**Sydney Metro Pitt Street South OSD
Stage 1 Modification (SSD 8876 MOD 2) & Stage 2 (SSD 10376)**

Attachment A

## RESULTING PITT STREET SETBACK

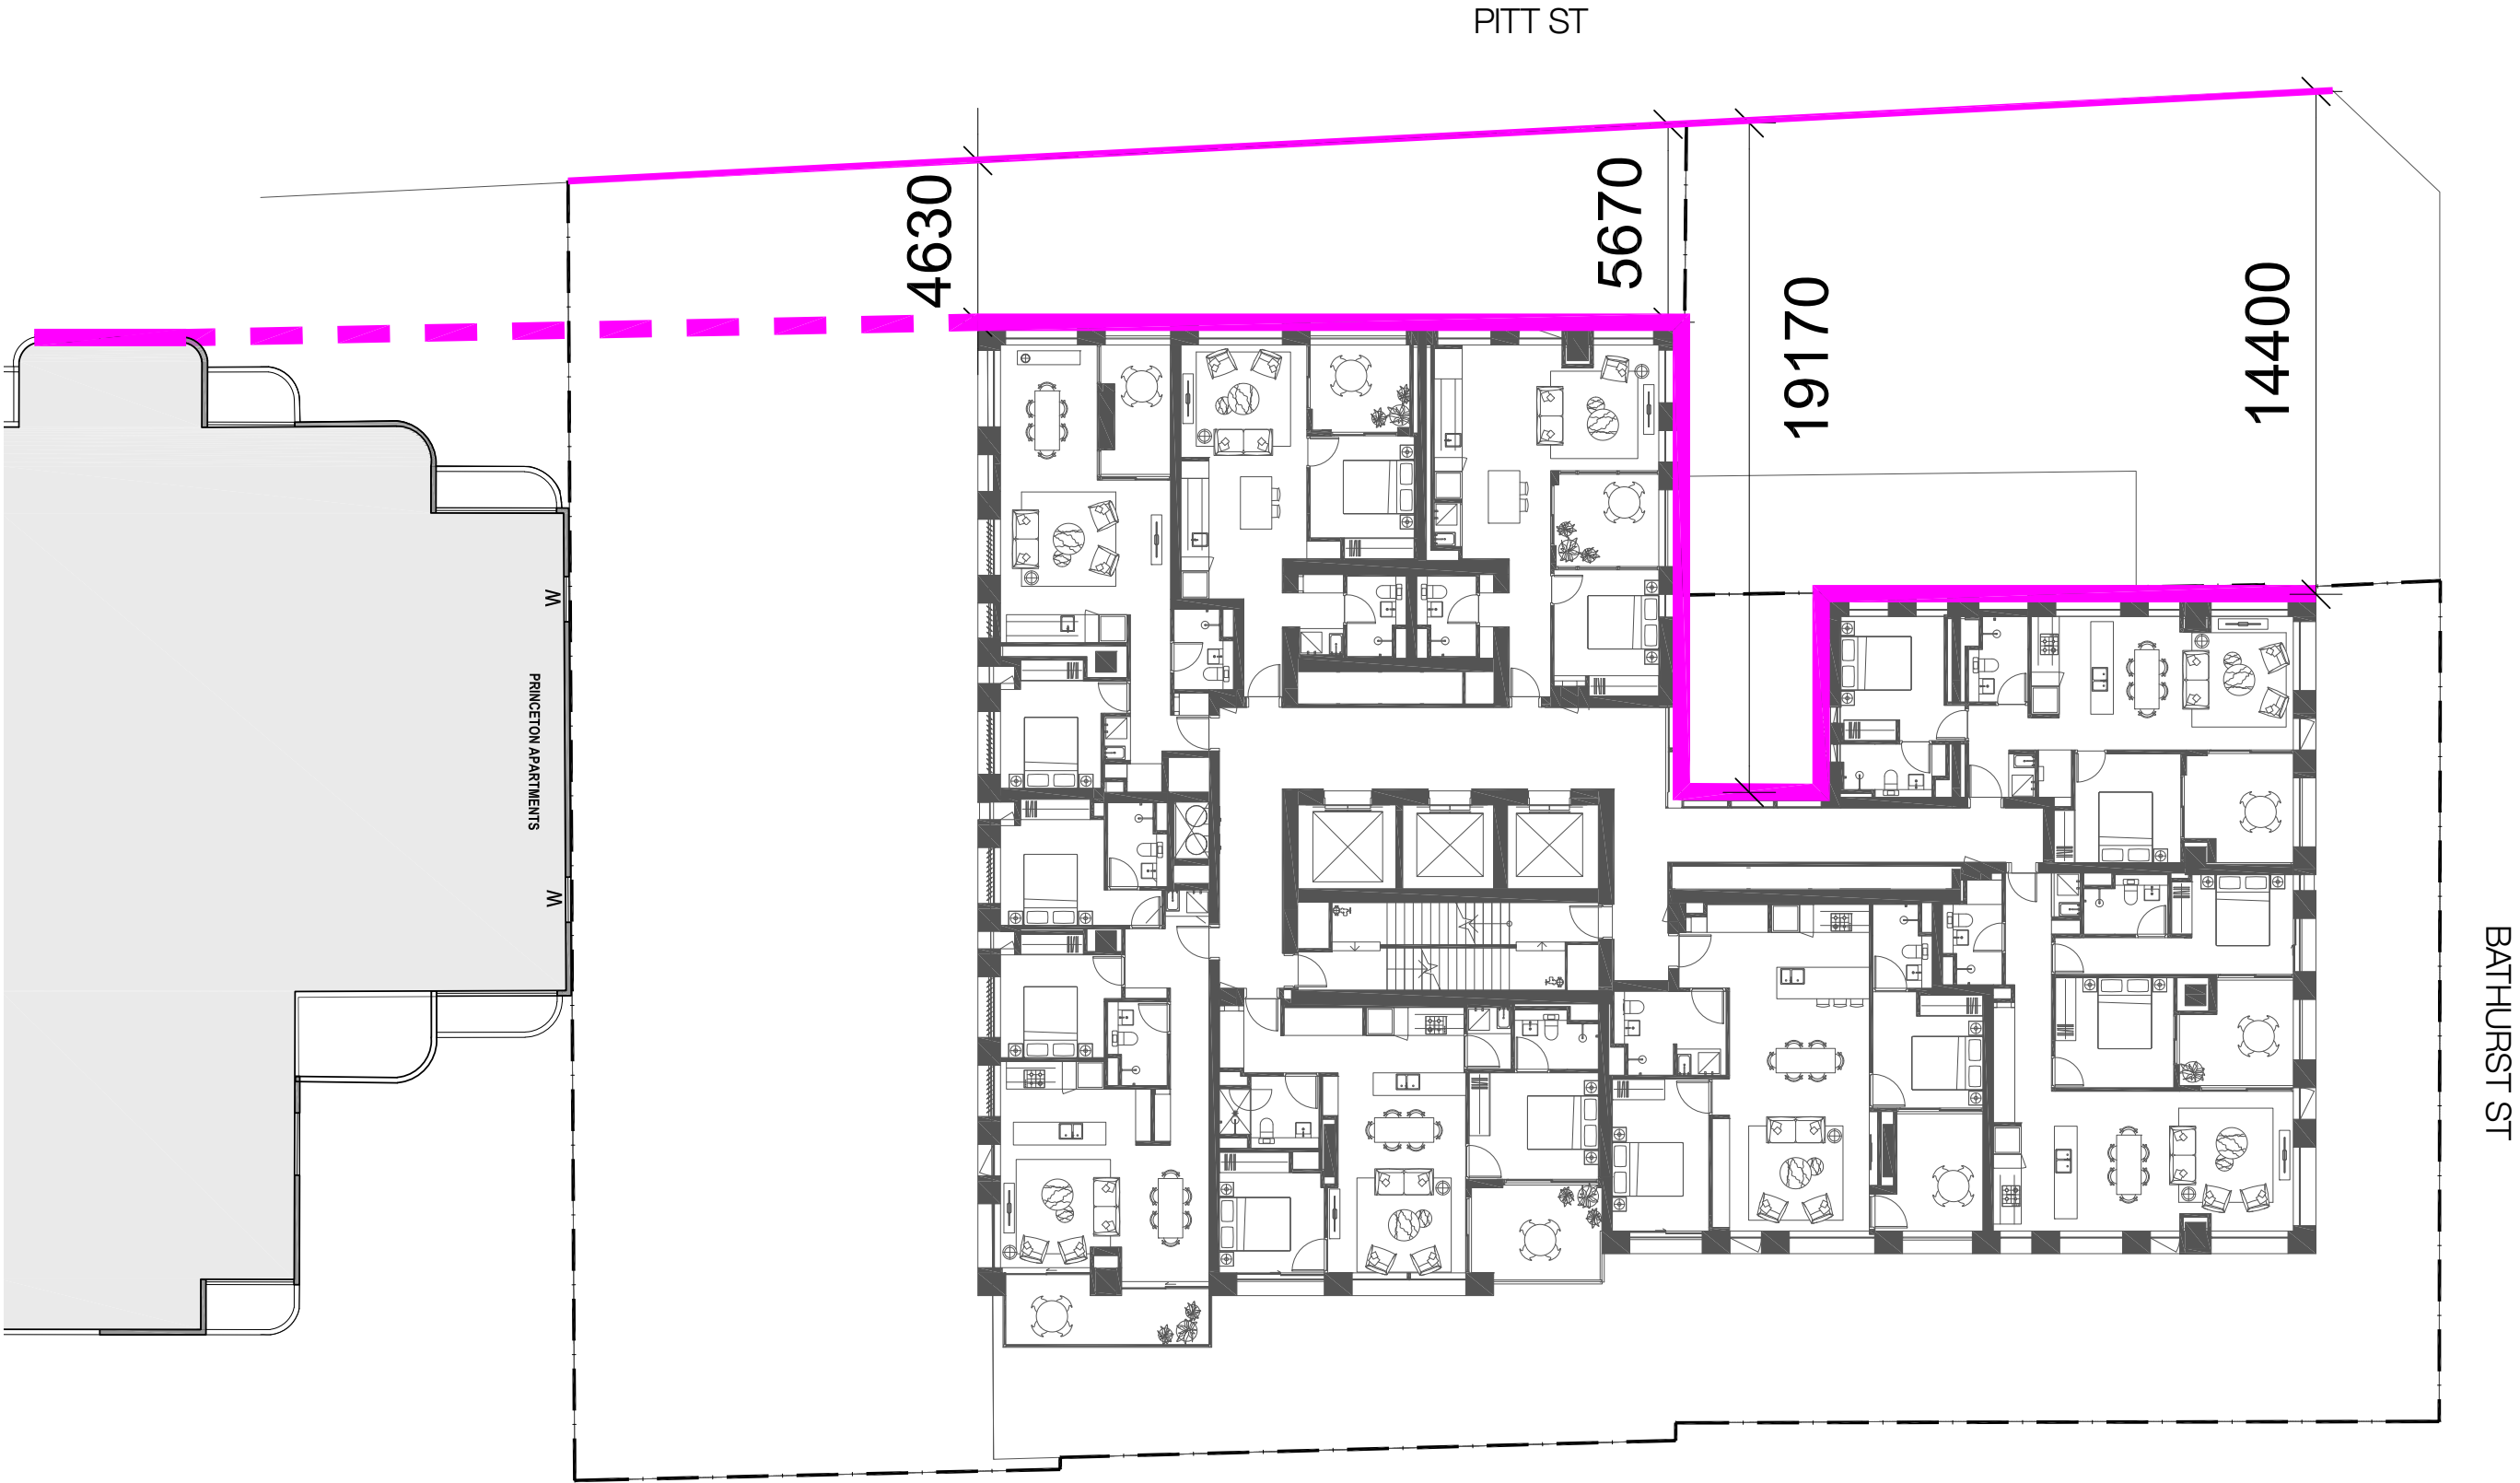
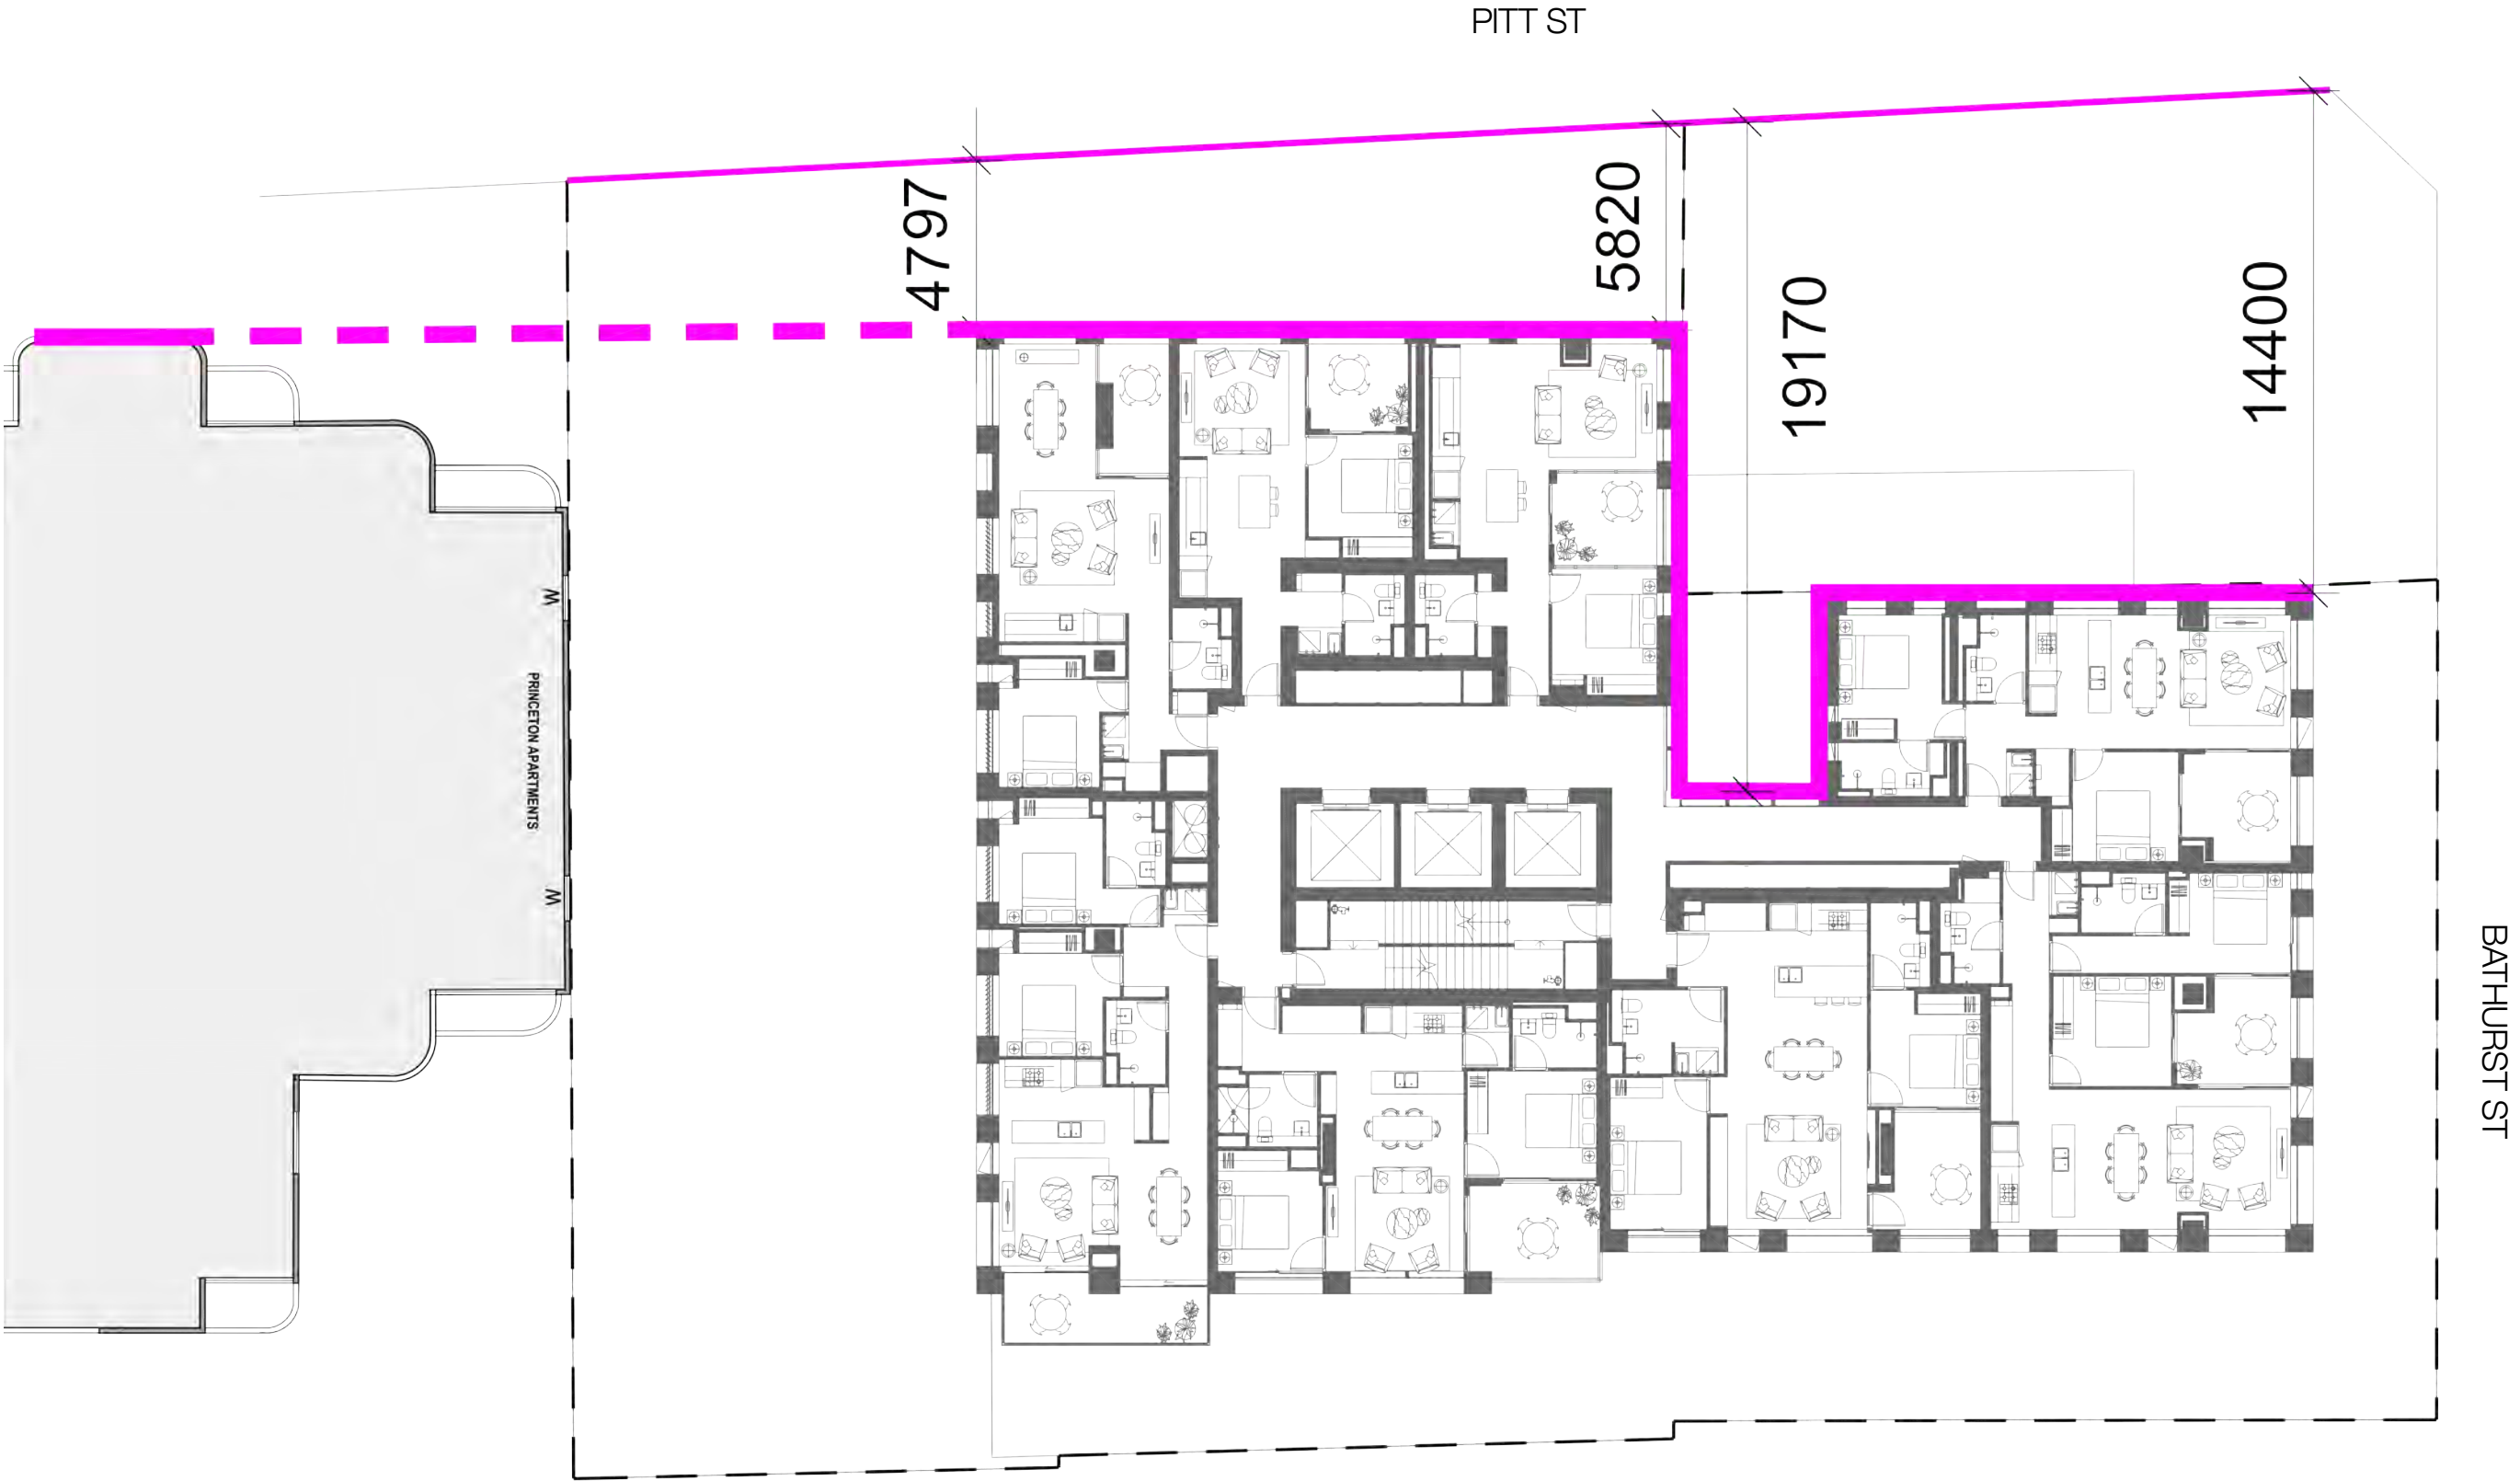
- (e) a varied setback from the Pitt Street boundary of the site, with the articulation of built forms be designed to minimise solar impacts to the living rooms of Princeton Apartments

Level 06 Terrace\_SSDA\_Plan

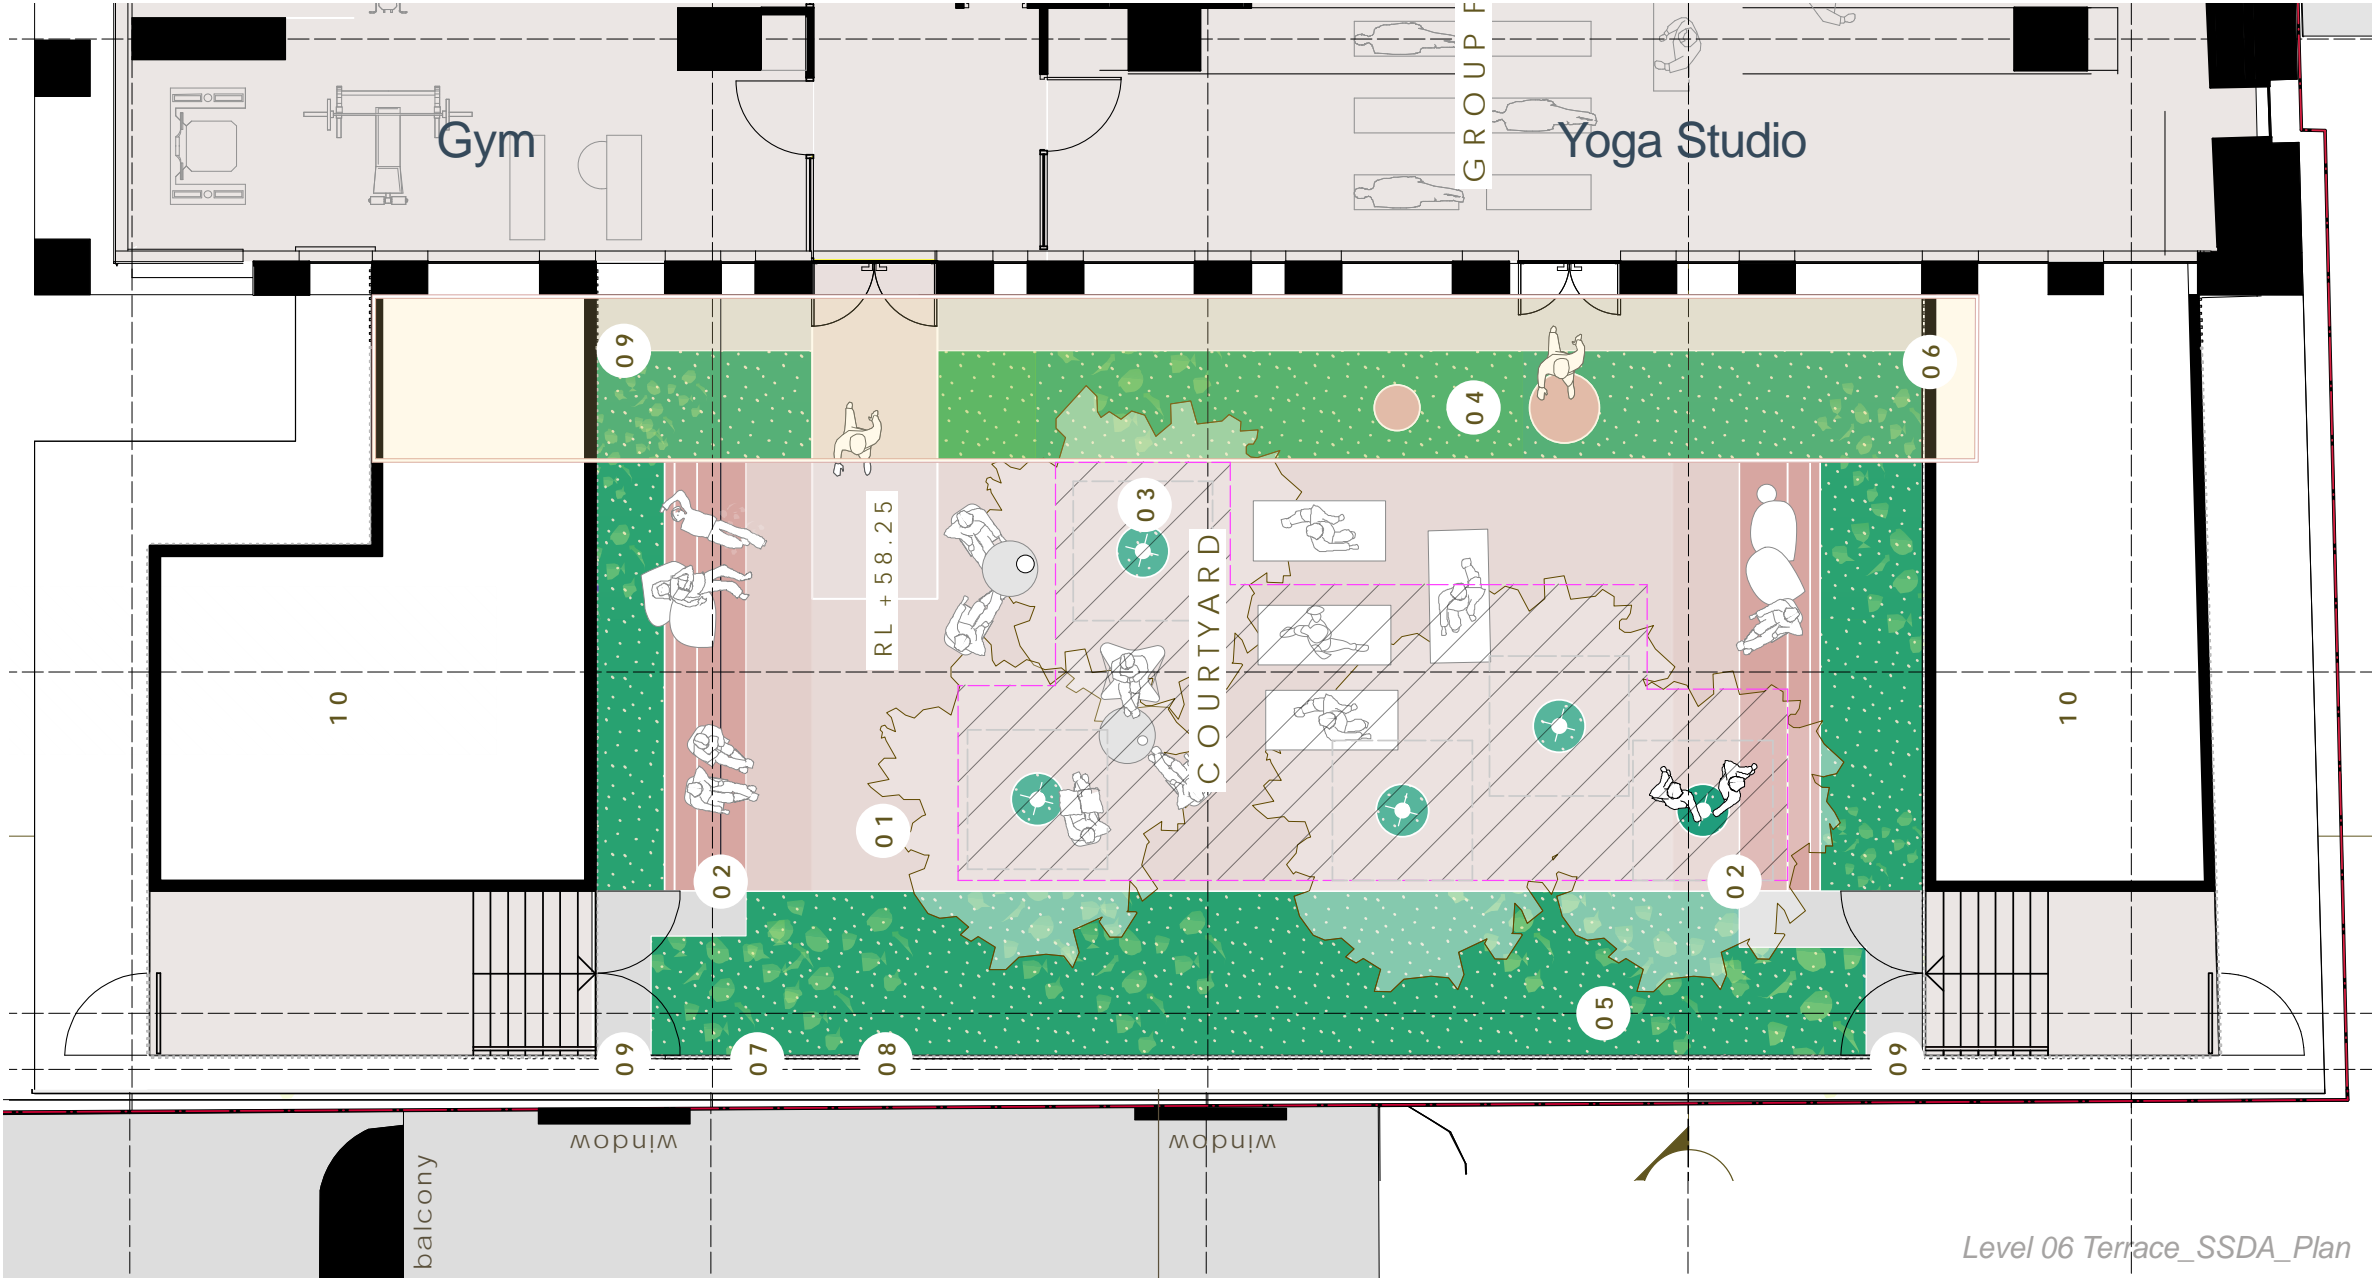
- the appropriateness of the location and design of the proposed communal open space adjacent to the Princeton Apartments on Level 6
 - any potential maintenance and acoustic issues from the proposed ventilation slots for south facing units
